**Our Case Number: ABP-316828-23**

**Re:** Tallaght/Clondalkin to City Centre BusConnect Core Bus Corridor Scheme.  
Tallaght/Clondalkin to Dublin City.

# South Dublin County Council Submission on Bus Connects

Tallaght/Clondalkin to City Centre Core Bus  
Corridor Scheme.

Programme Title BUSCONNECTS DUBLIN CORE BUS CORRIDORS INFRASTRUCTURE WORKS			
Drawing Title TALLAGHT/CLONDALKIN TO CITY CENTRE CORE BUS CORRIDOR SCHEME STREET LIGHTING			
Drawing File Name BCIDA-ACM-LHT_RL-0809_XX_00-DR-EO-0011	Sheet Number 11 of 56	Status A	Rev M01

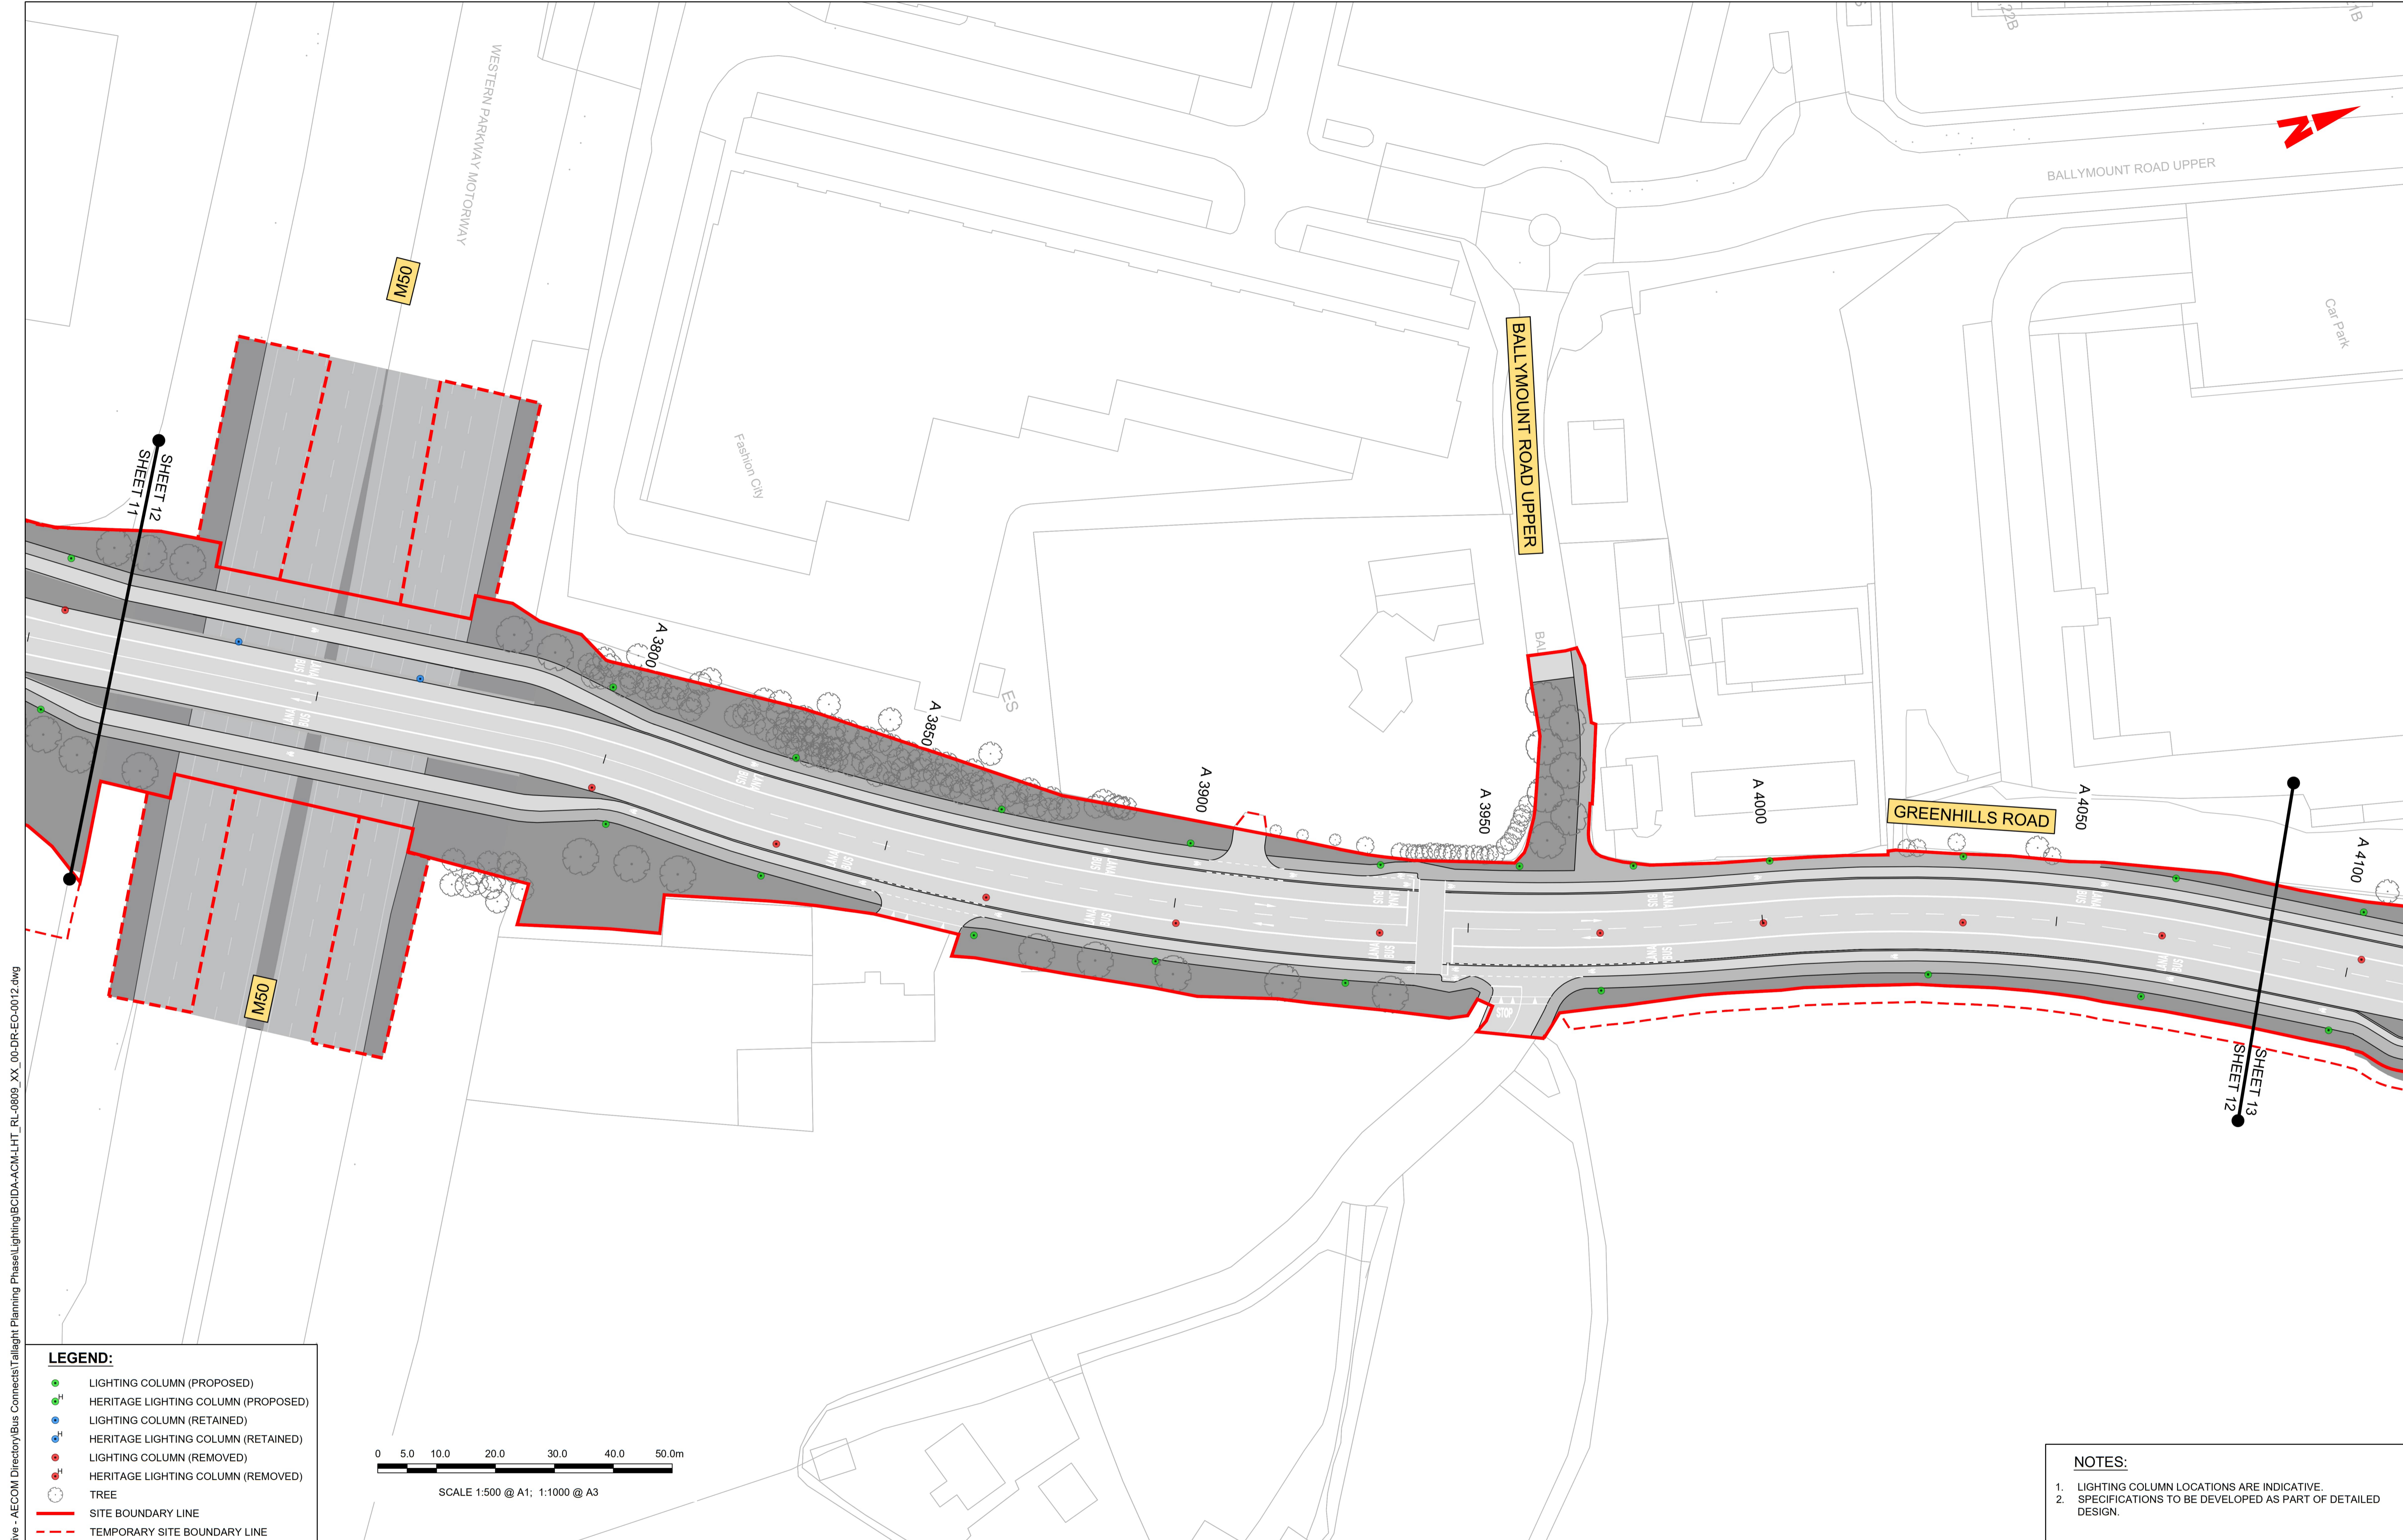
- (e) The scheme should clearly set out how the NTA will re-provide a high-quality open space at Mayberry Road and Birchview Avenue as the scheme does affect the existing amenity of Green open space at these locations. The proposal to use this open space as a temporary site compound could create negative impacts on surrounding residential areas and the final design and layout, visual impact, hours of operation, traffic and noise should be secured by planning condition for agreement with the Local Authority. **(Sheets 9, 10 and 11 of 56 on General Arrangement Drawings)**

Drawing Title
 TALLAGHT/CLONDALKIN TO CITY CENTRE SCHEME
 ST01.09 - GREENHILLS ROAD PEDESTRIAN & CYCLE BRIDGES
 PLAN

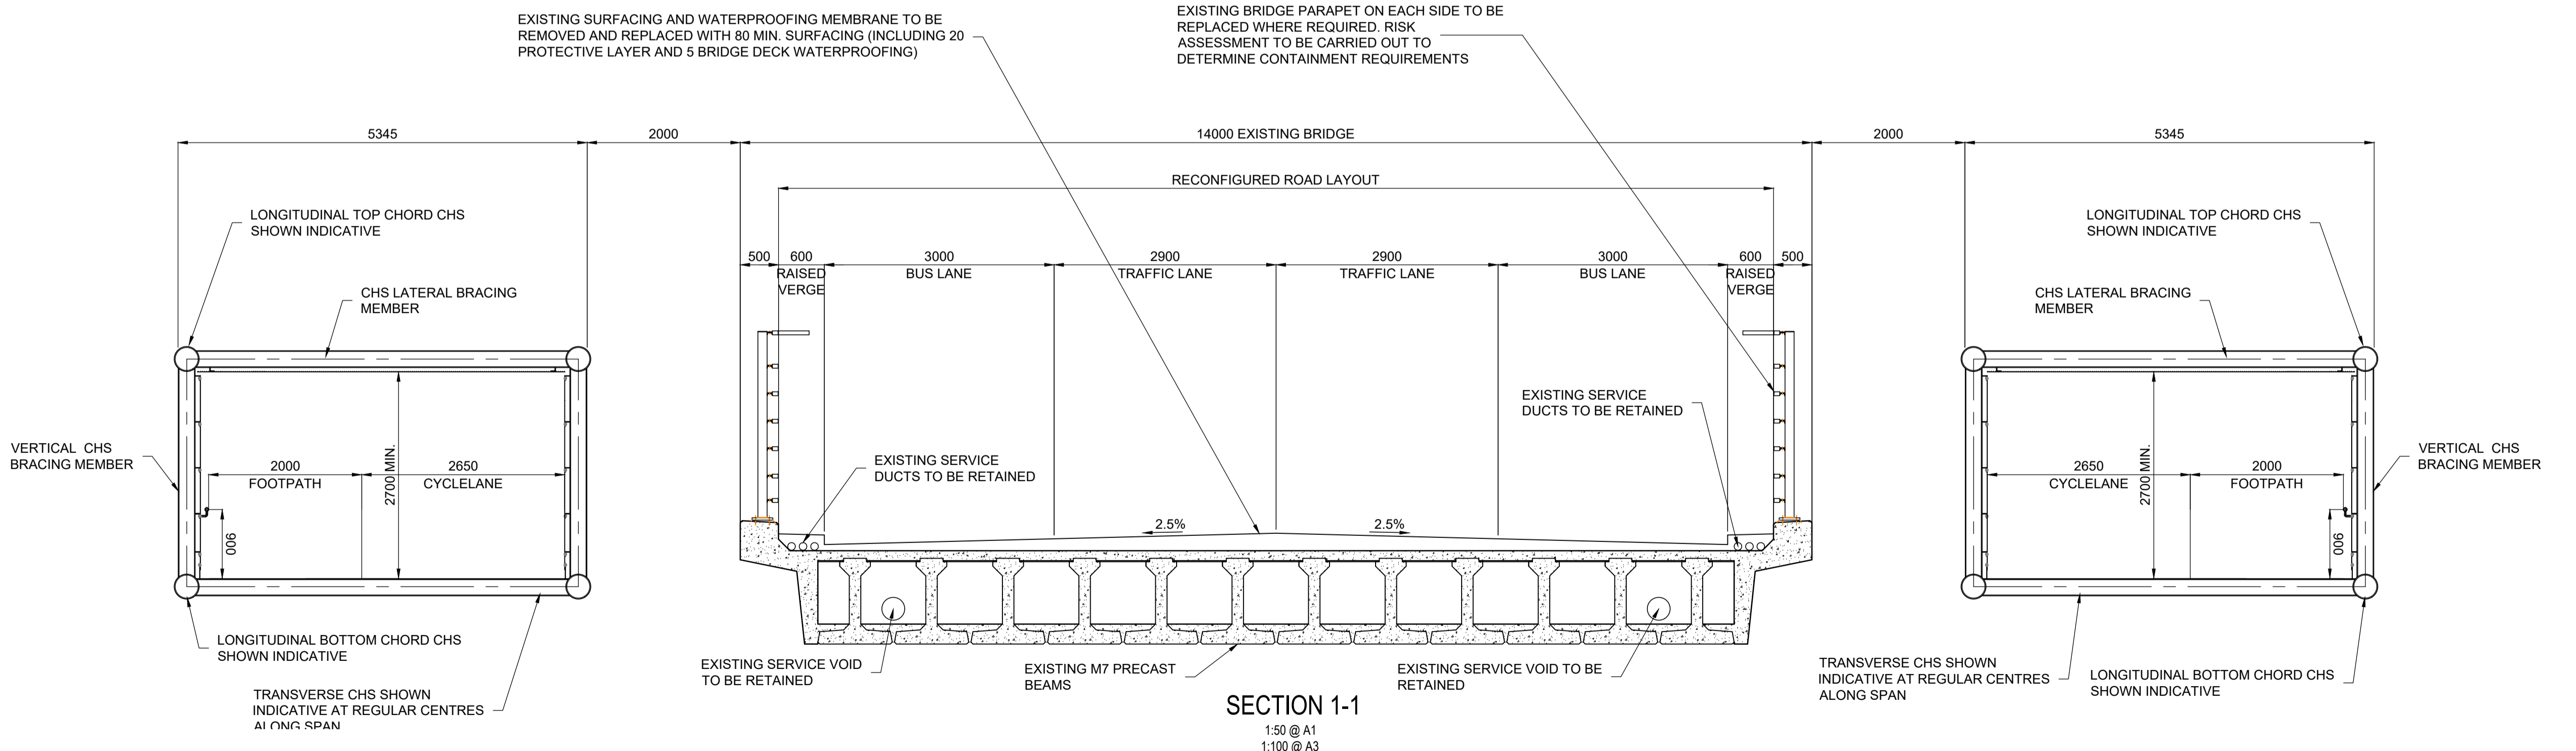
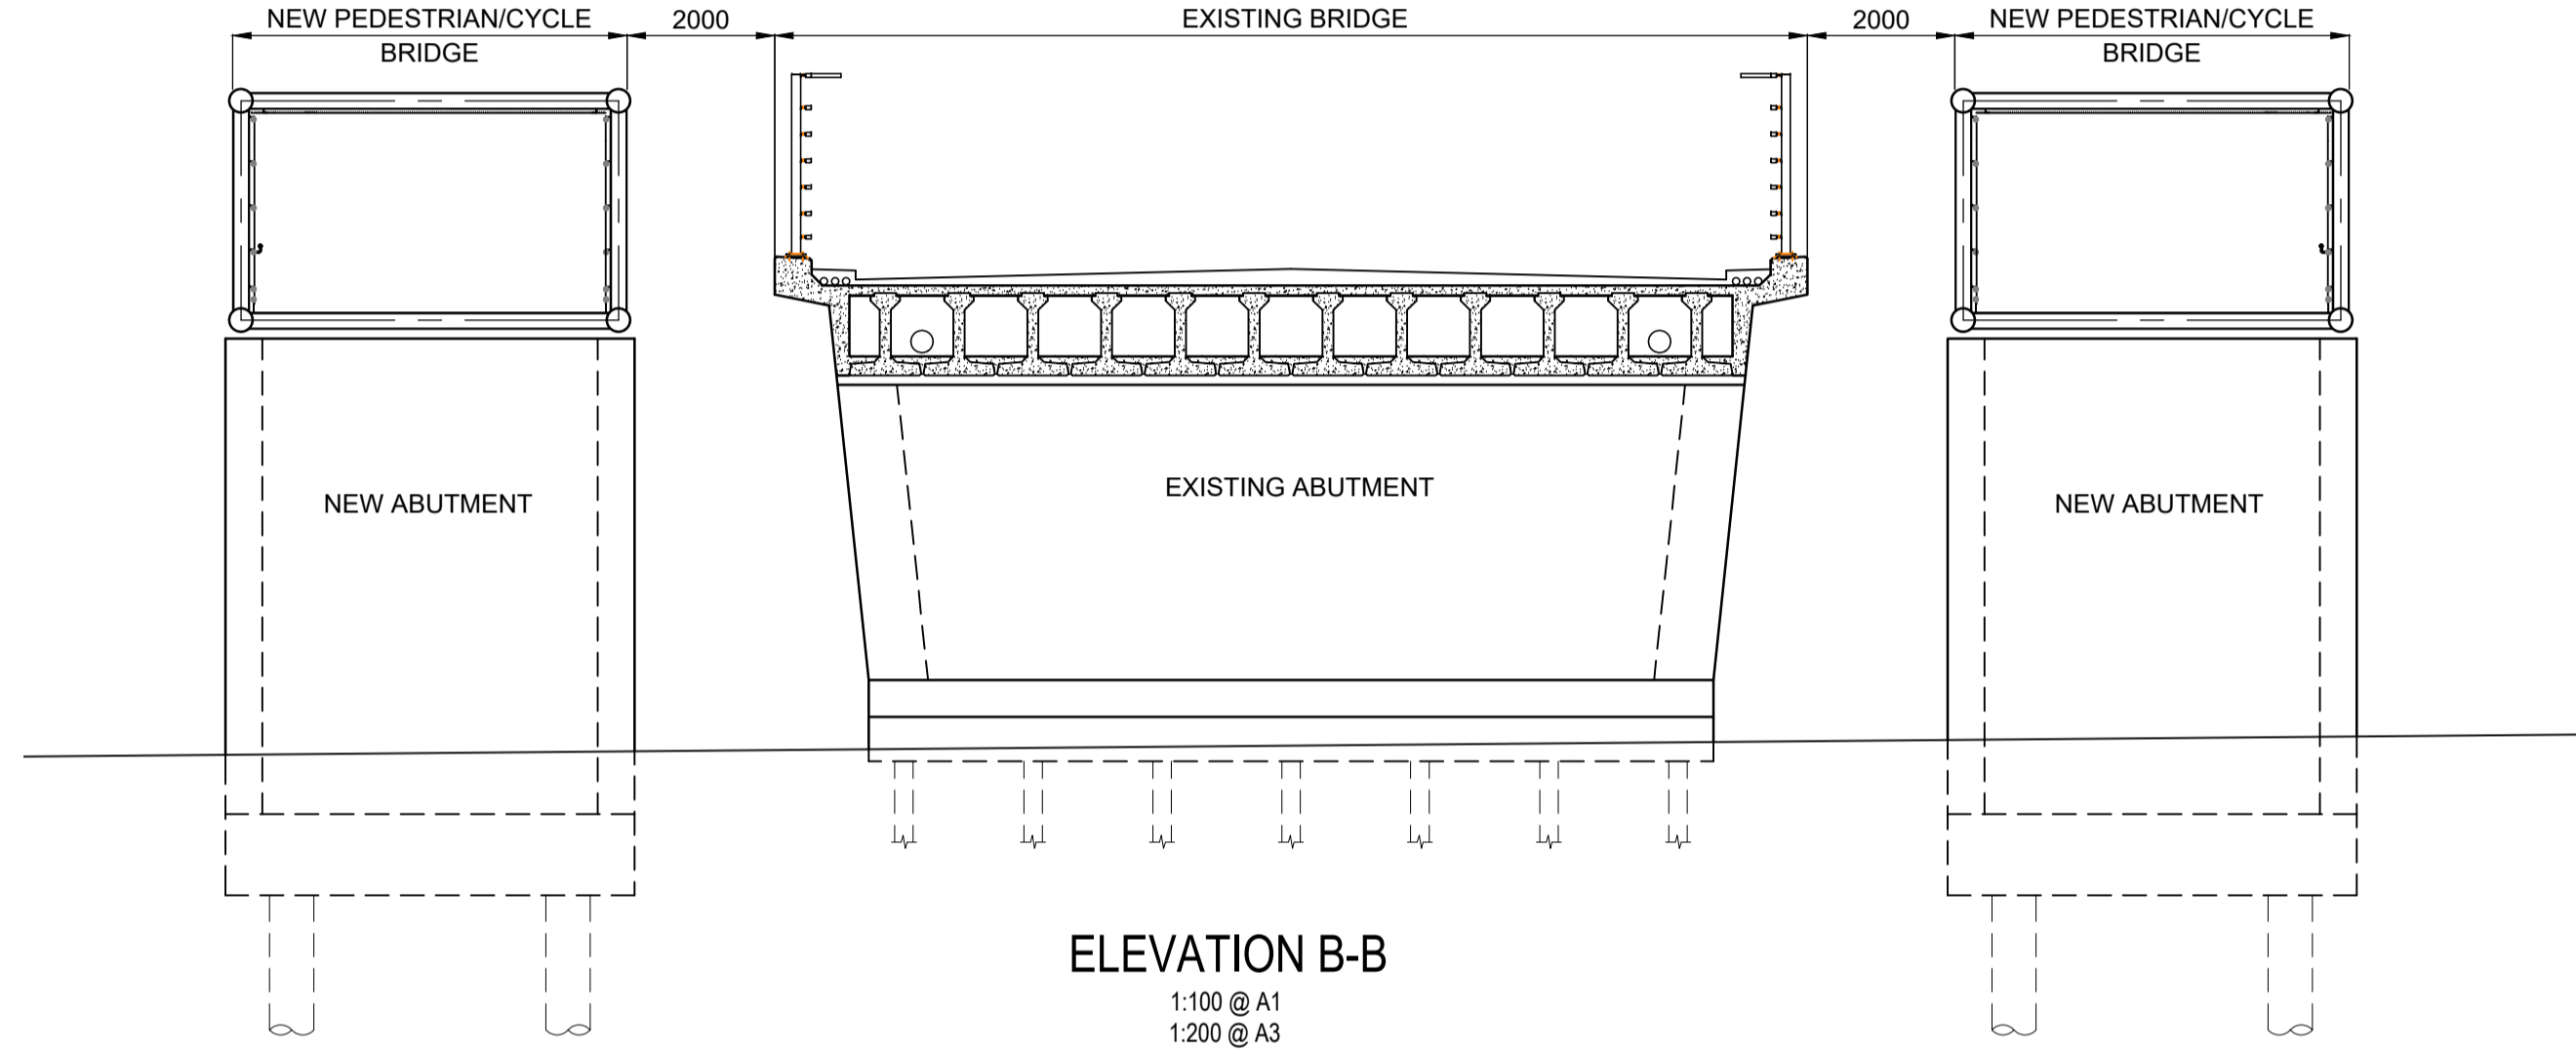
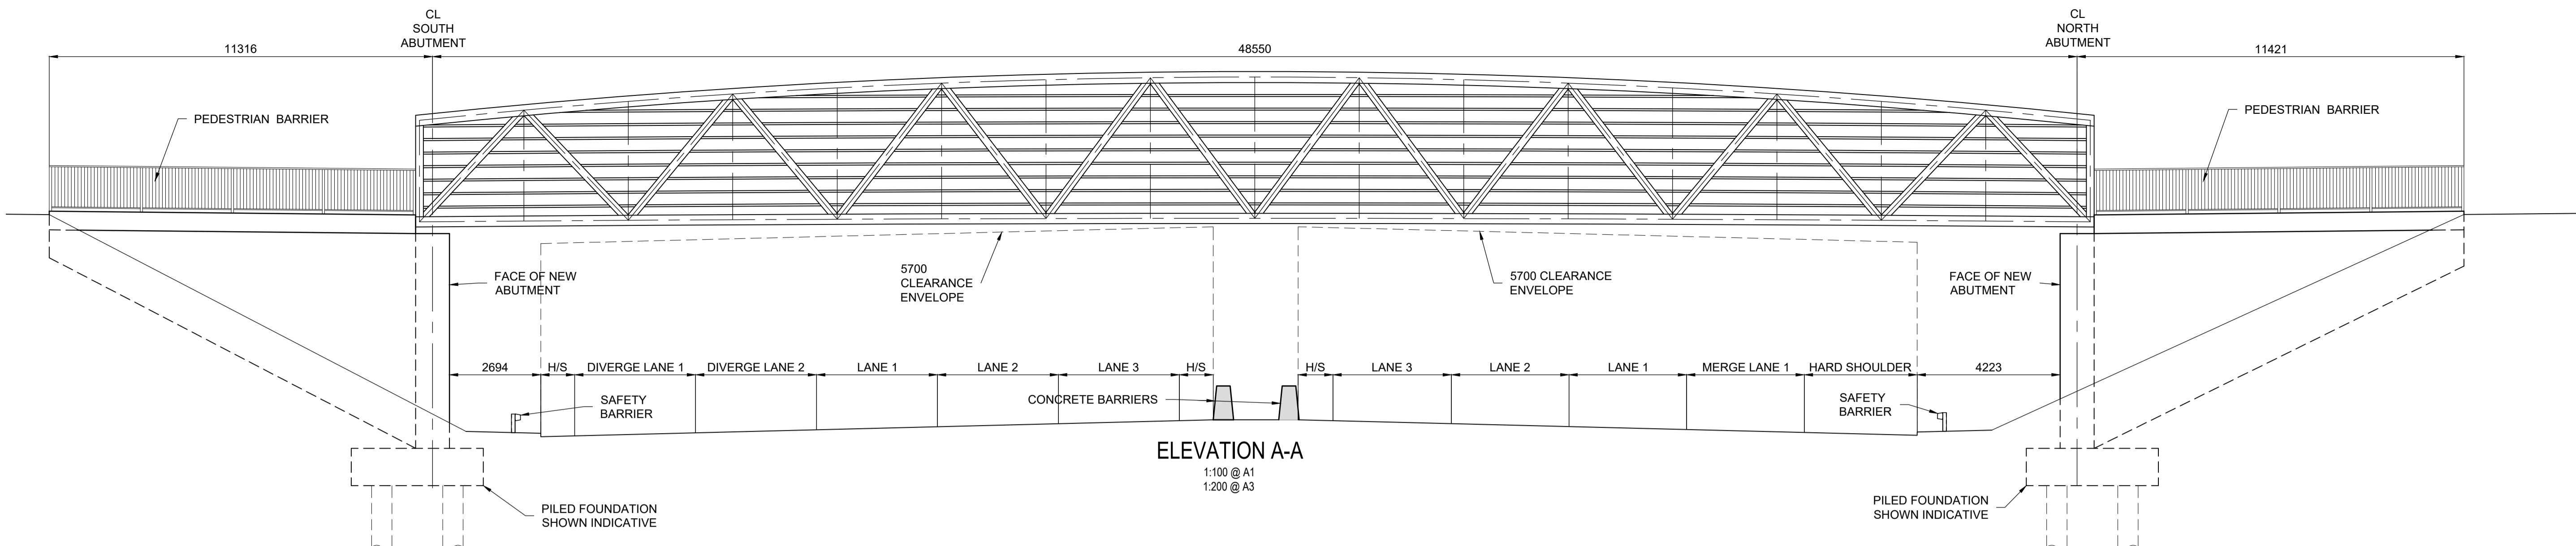
- b. The proposed cycle bridge and ramp. appears of standard engineering specification, and an uplift in design quality and appearance is warranted in this important location at a key entry in the wider City Edge regeneration lands, including for example

- The ramps and crossings need to be a minimum of 10m wide to attract users providing for a min of 3m ped and 2m cycle lanes in both directions.
    - The landing/arrival spaces need to be sufficiently sized, open and well designed incorporating planting and signage

- The railings and surface treatments needs to be of the highest quality, robust and durable
    - It needs to be well lit.
    - Clear and well considered wayfinding and sign posting
